Sent: 05 September 2018 11:30
To: Charlotte Burrows
Cc: 'Alexia Brooke'
Subject: RE: Mayaro House, Hook Lane, Aldingbourne

I write to you regarding the recent application submitted at Mayaro House, Hook Lane – reference AL/76/18/HH. The application has now been passed onto me to deal with and I am starting to write the report.

PROPOSED DETAILS

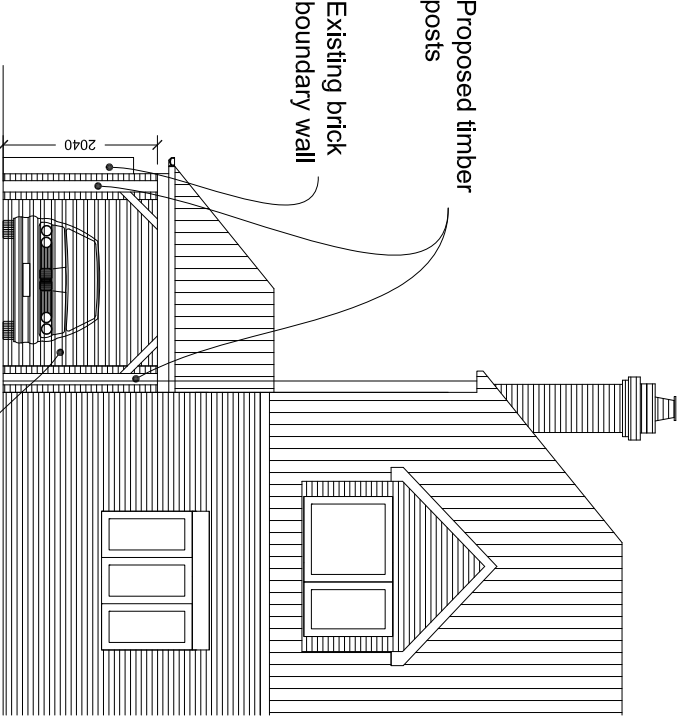
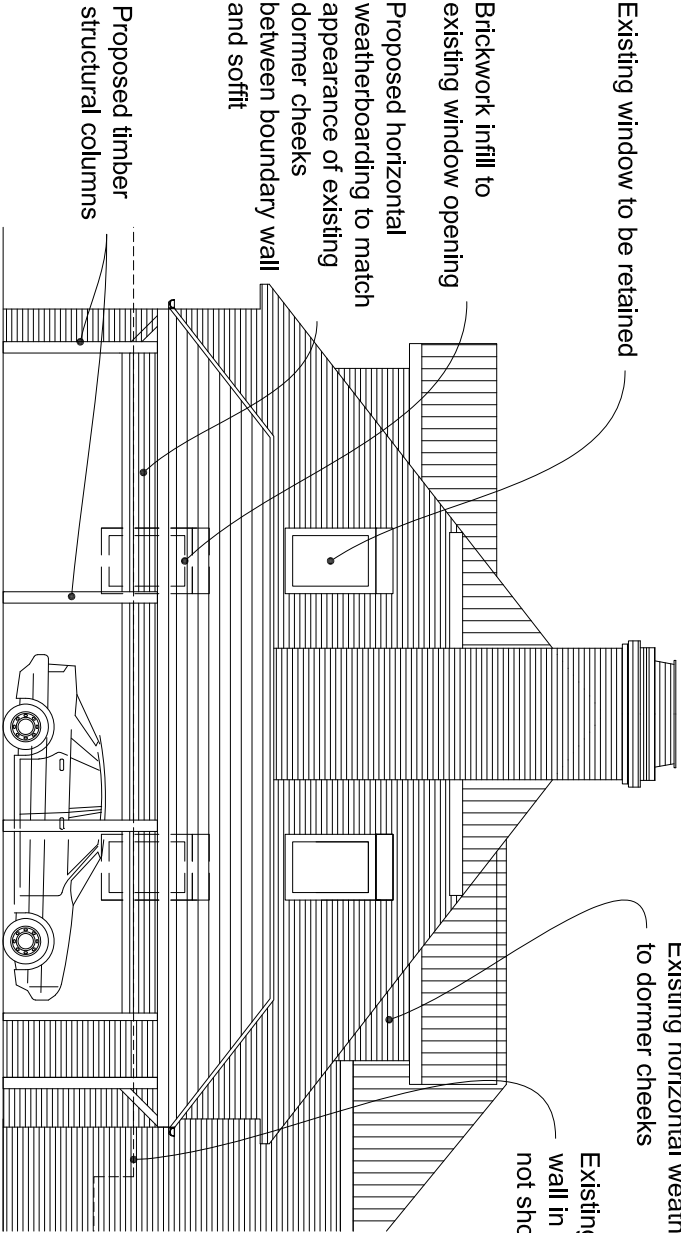
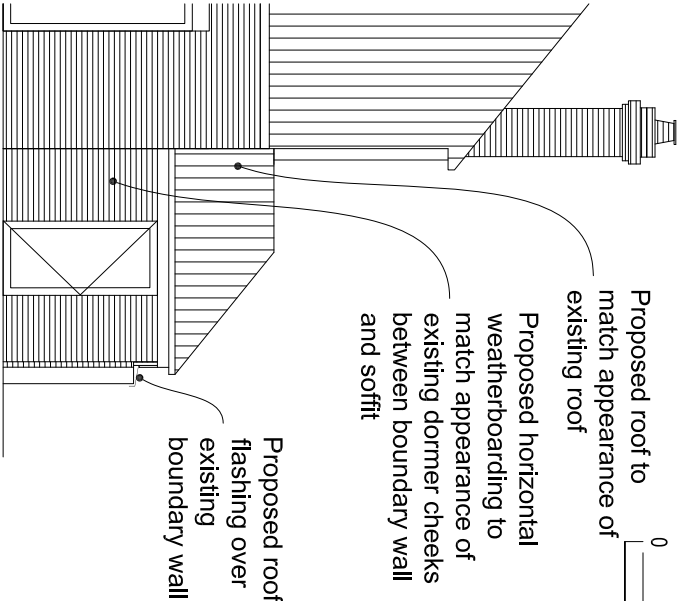
We have had an objection due to the fact the proposed roof appears to overhang the boundary wall. Could you please confirm if this is the case? If it is then please note you will be required to serve notice on the land owner of the adjacent path/road, amend the application forms submitted and then amend the red edge indicated on the location and block plan.

When I first became aware of this objection, I spoke to your colleague Amber Willard on Tue 21/08/2018 and explained that our proposal does not overhang the boundary wall. As you can see from the enlarged part-elevation / detail below, roof including the gutter is within applicant's property.

The boundary wall is in applicant's land, and it is owned and maintained by the applicant.
